I refer to the email of 12 December 2023 requesting advice from the Environment and Heritage (EHG) on the Environmental Impact Statement (EIS) for the Honeman Close Data Centre proposal (SSD-58601963).

BCS has reviewed the Biodiversity Development Assessment Report (BDAR) and the Flood Risk and Impact Assessment supporting the EIS and provides the following advice in relation to the biodiversity assessment. BCS has no flood risk assessment comments.

Figure 2: Location of the Conservation Area and the Landscape Buffer Zone

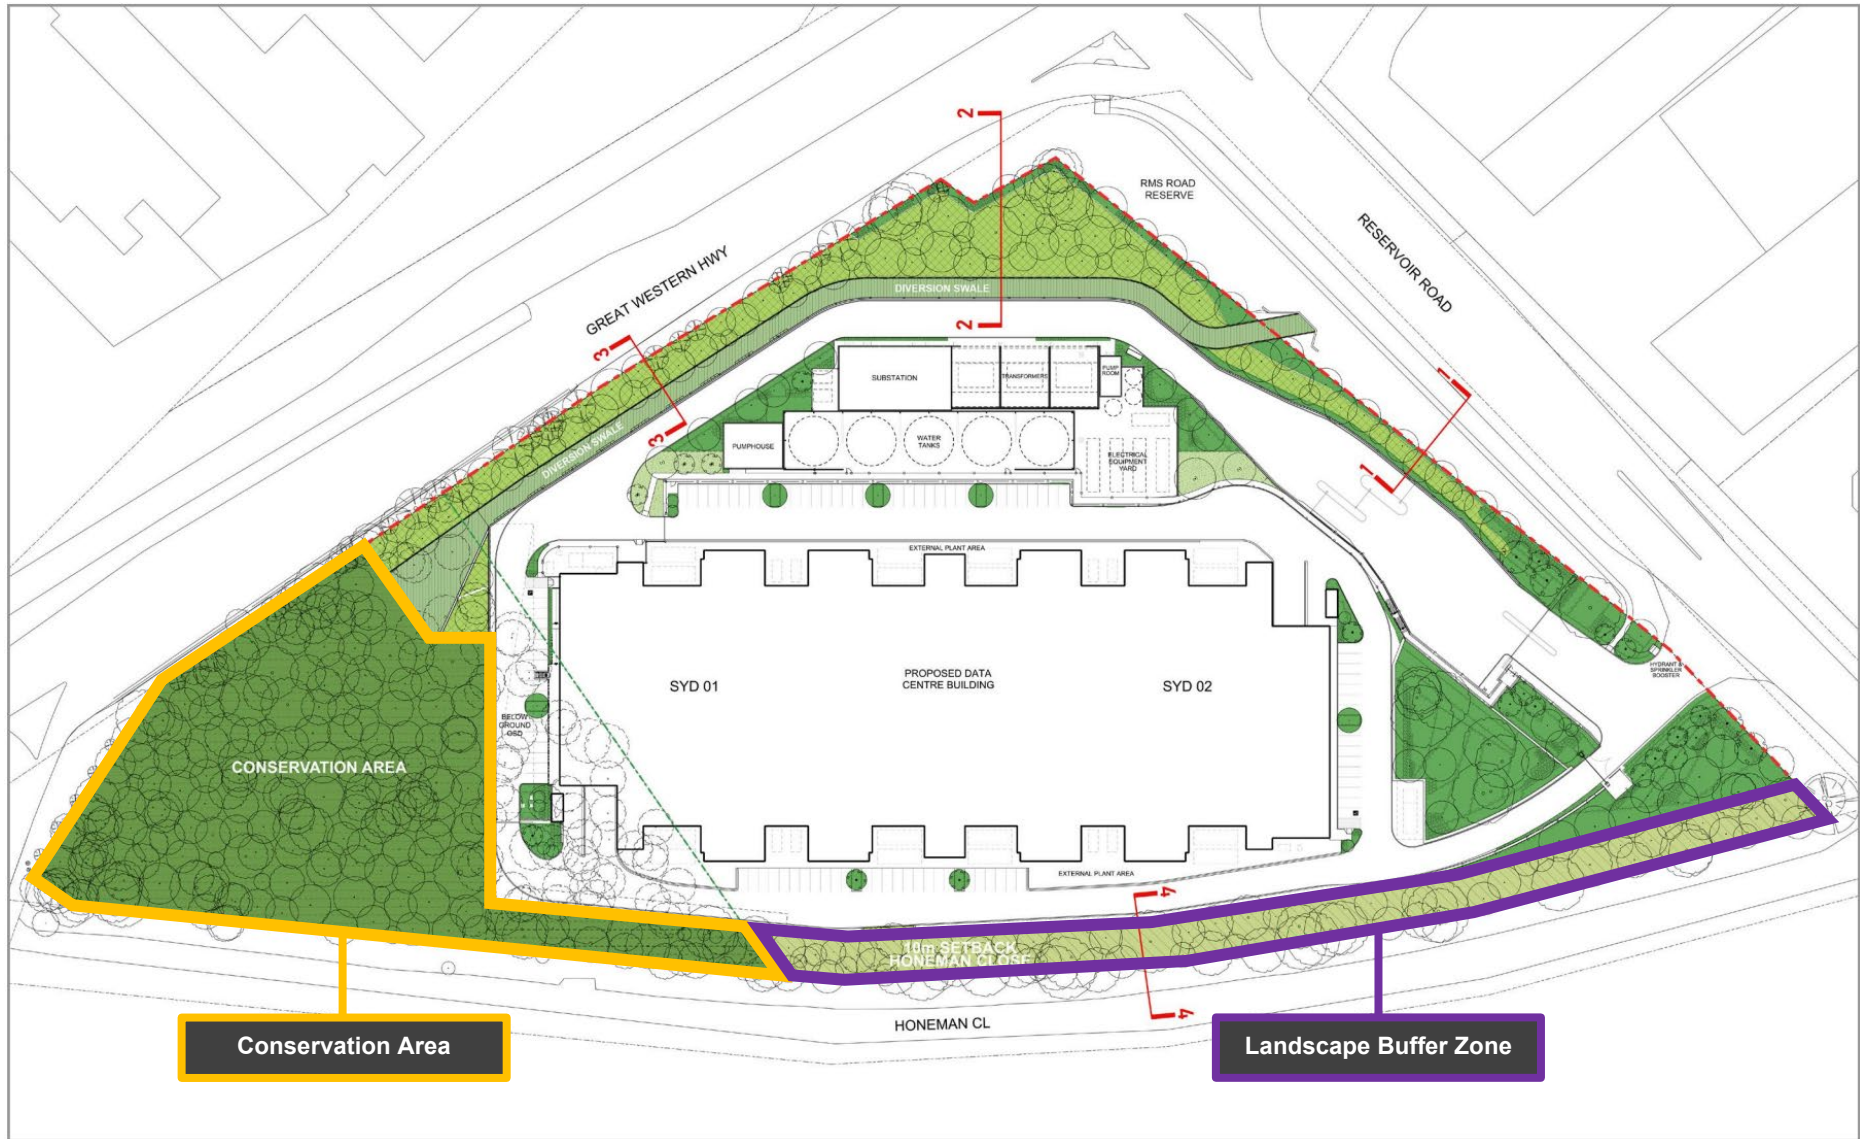
BCS also notes the statement in the BDAR introduction that the '*proposed Data Centre is generally consistent with the aims and objectives of the approved VMP although it recognised that it would reduce the area of conservation from 1.11 ha to 0.78 ha. This has been further addressed in Section 10.8.*' In addition to updating the VMP in accordance with the revised extent of works, BCS advises that if the SSD application is further progressed, the proposed offset obligations would need to be updated in accordance with any modified proposal.
